From: [REDACTED]
To: [M25 Junction 28](#)
Subject: Gardens of Peace - comments on responses to Written Representation
Date: 25 February 2021 19:40:22
Attachments: [20200225 - Comments on Responses to WR's - Final.pdf](#)

Savills, on behalf of Gardens of Peace Muslim Cemetery, submit the following comments in regards to Highways England's response to the Written Representation. We first outline our comments to each specific response (Part 1), before providing a key summary of comments on Highways England's Responses (Part 2). We reserve the right to discuss the below points, and the concerns highlighted within the Written Representation, in greater detail during the oral hearing.

Project Title	M25 Junction 28
Drawing Title	FIGURE 6.9 SHORT TERM CHANGE (DS22-DM22)
Drawing Number	HE551519 - ATK - ENV XX - GS - GI - 000009
Original Size	A3
Scale	1:12,500
Project Ref. No.	---
Sheet	1 of 1
Rev.	C04

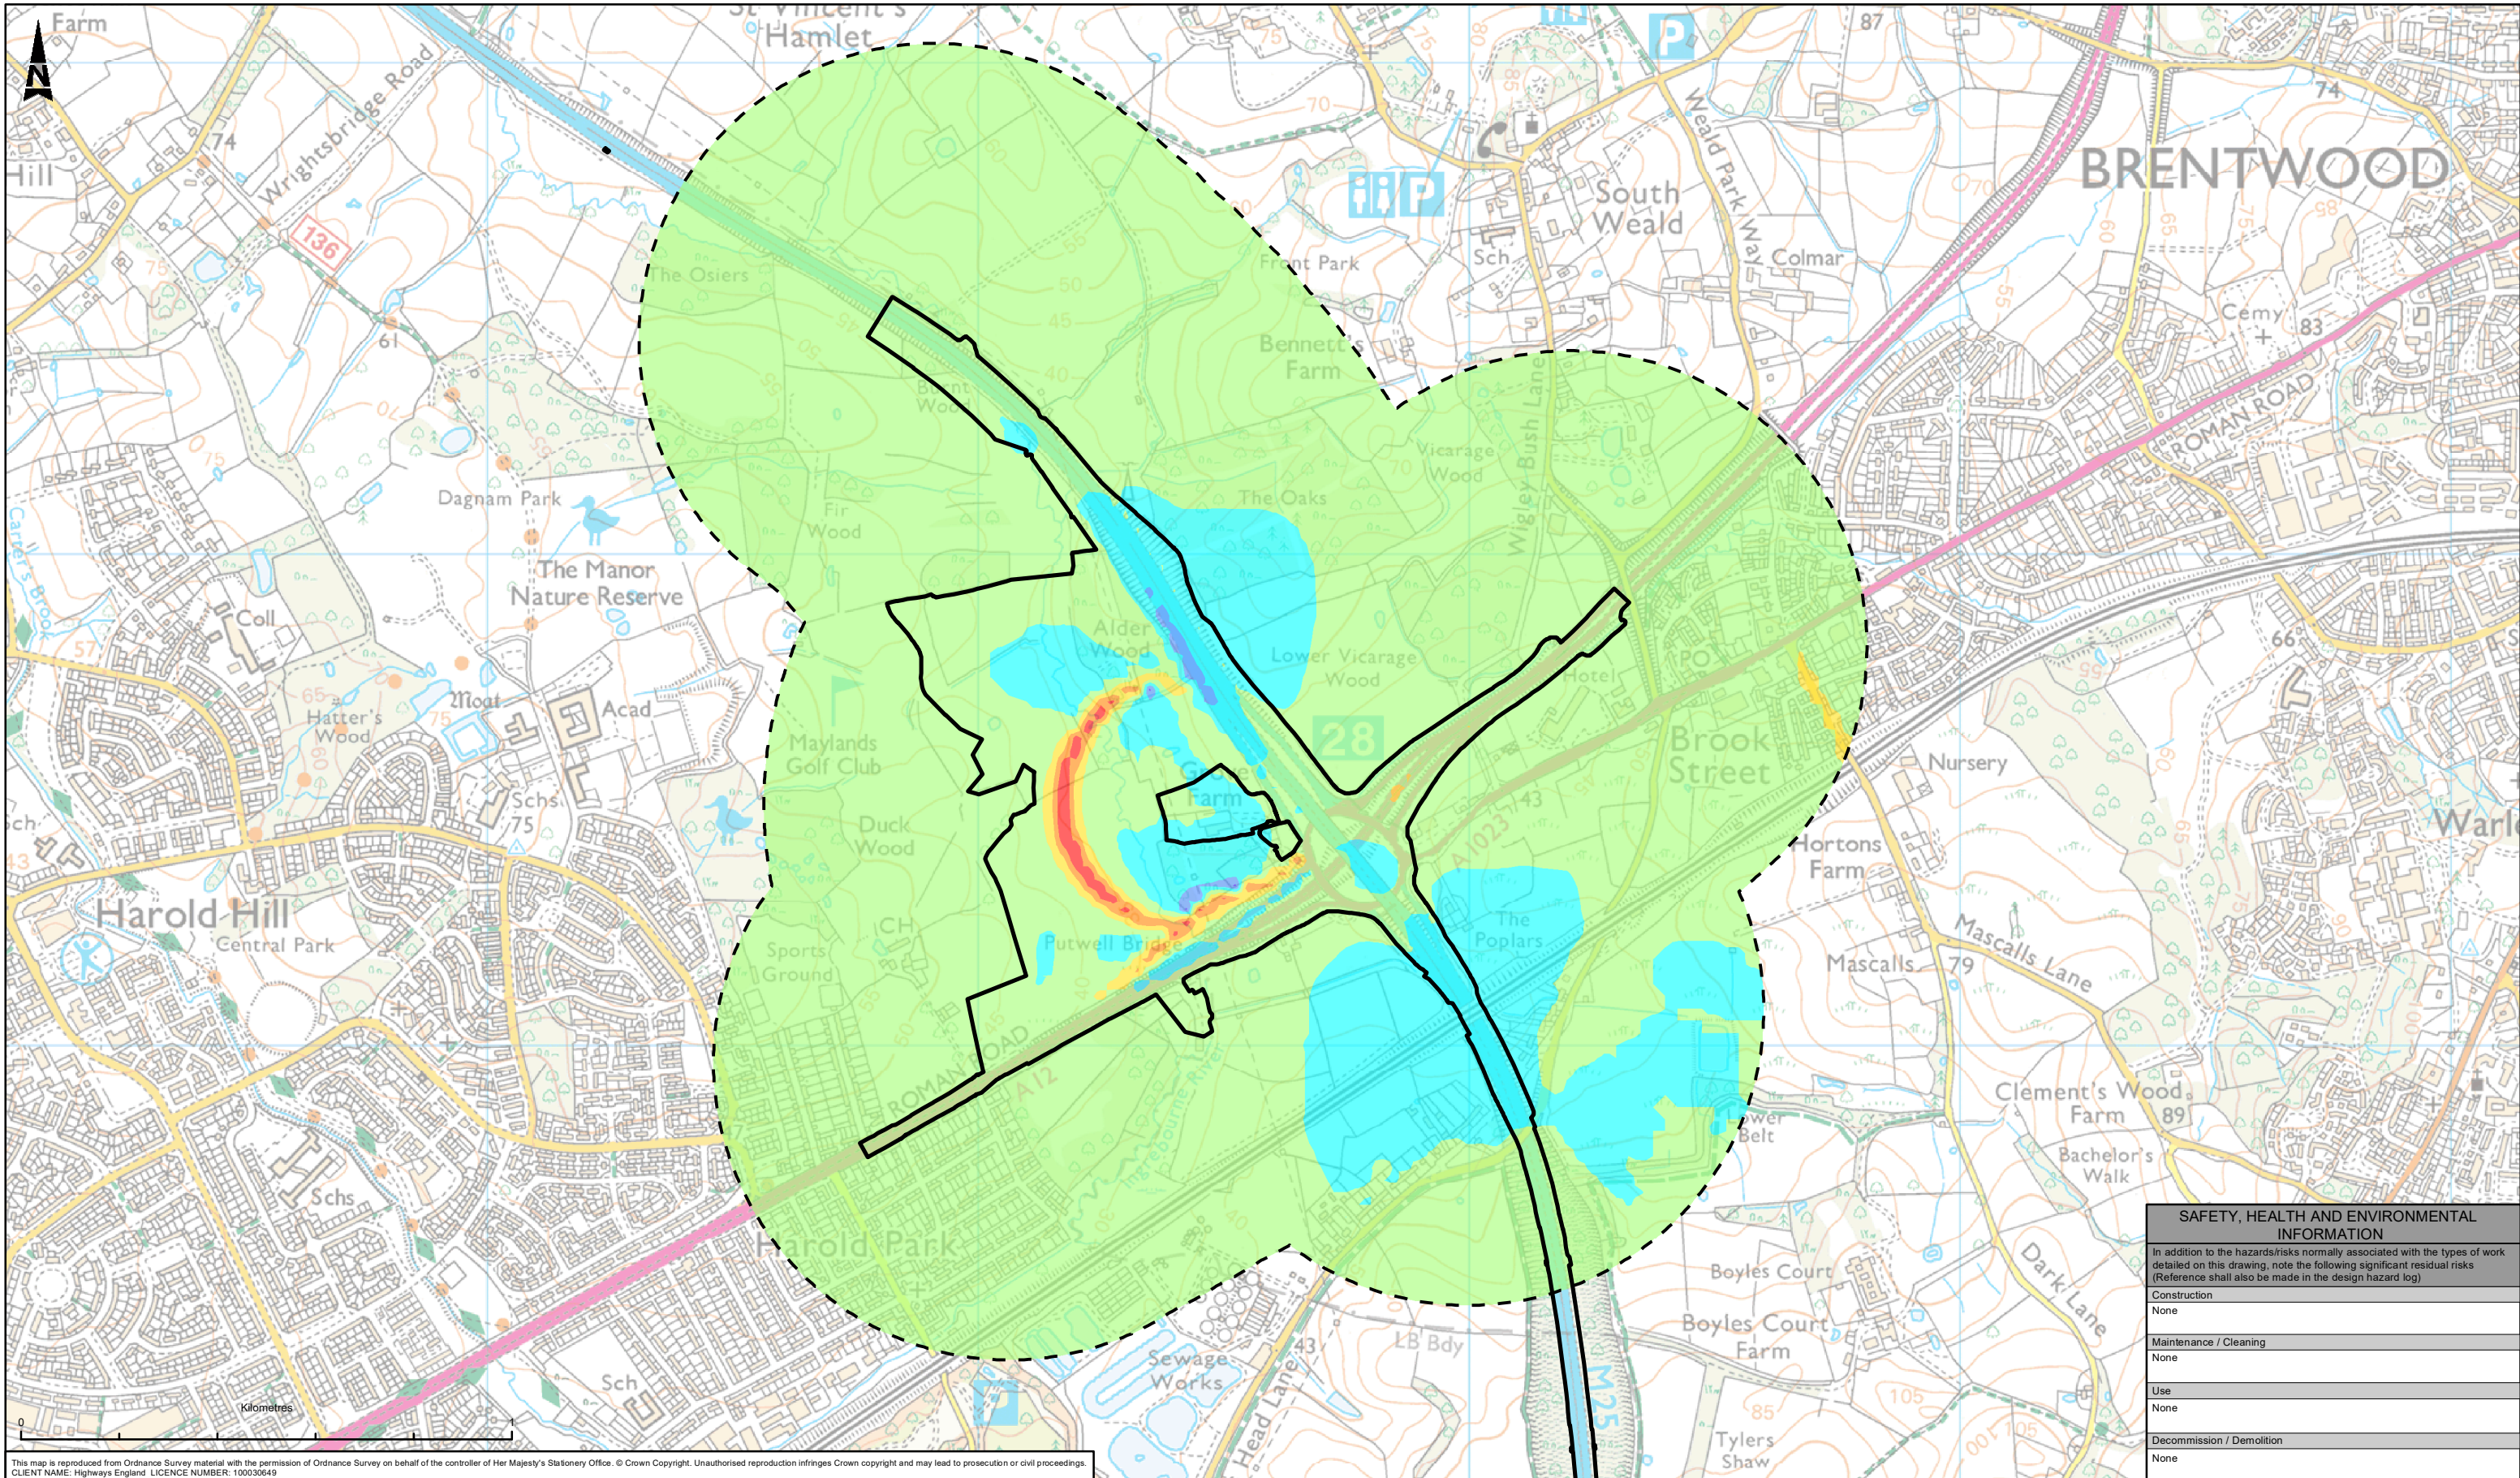
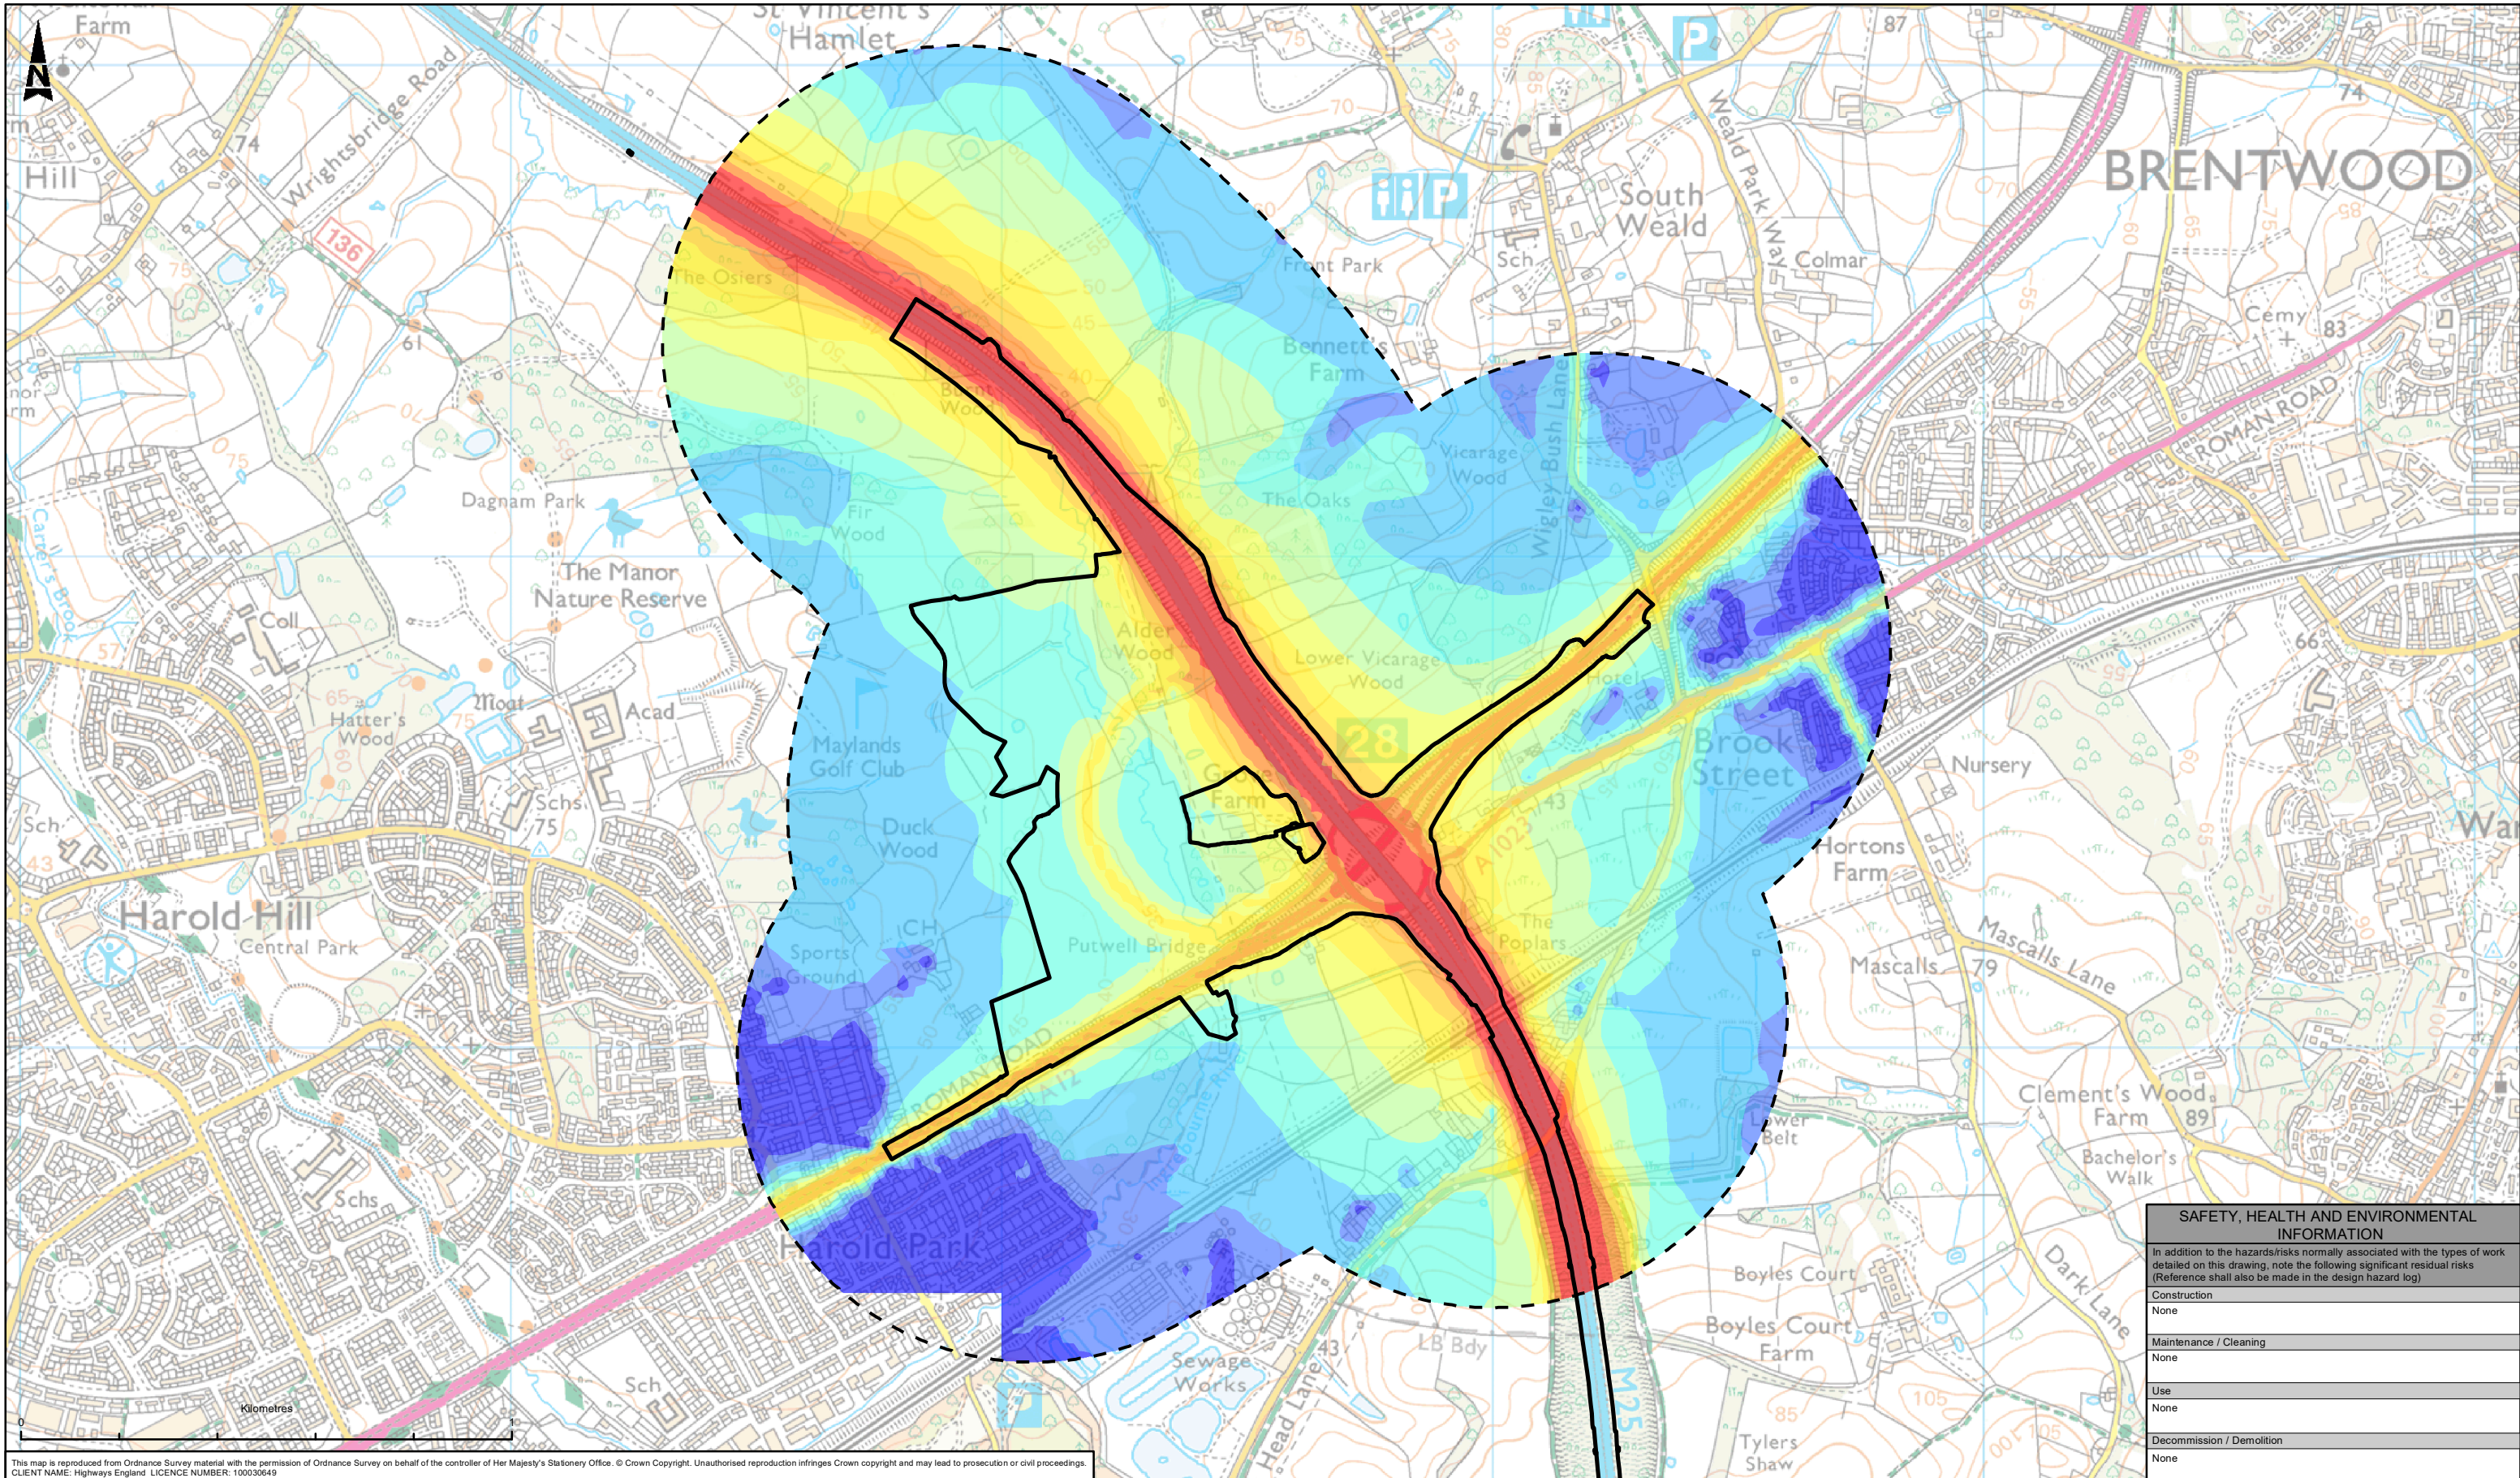
Gardens of Peace welcome the clarification on the expected reduction in noise level of 1dB.

The noise impacts at the Gardens of Peace can be seen on the noise contours in the ES (Figures 6.5 to 6.15, APP-041), and the impacts are summarised in point 12.1.1 of the Statement of Common Ground with London Borough of Havering (REP1-004). For further clarity a receptor position has been added for the Gardens of Peace and this is presented in the update of the Noise Chapter 6 of the ES (TR010029/APP/6.1(2)) submitted at this Deadline 3a. The Gardens of Peace receptor is included in the tables of receptors in the updated Appendix 6.3 (TR010029/APP/6.3(2)) submitted at Deadline 3a. The table below is extracting the noise results from Table 6.1 of the updated Appendix 6.3 (TR010029/APP/6.3(2)). The changes in noise expected at the Gardens of Peace are decreases in noise smaller than 1dB.
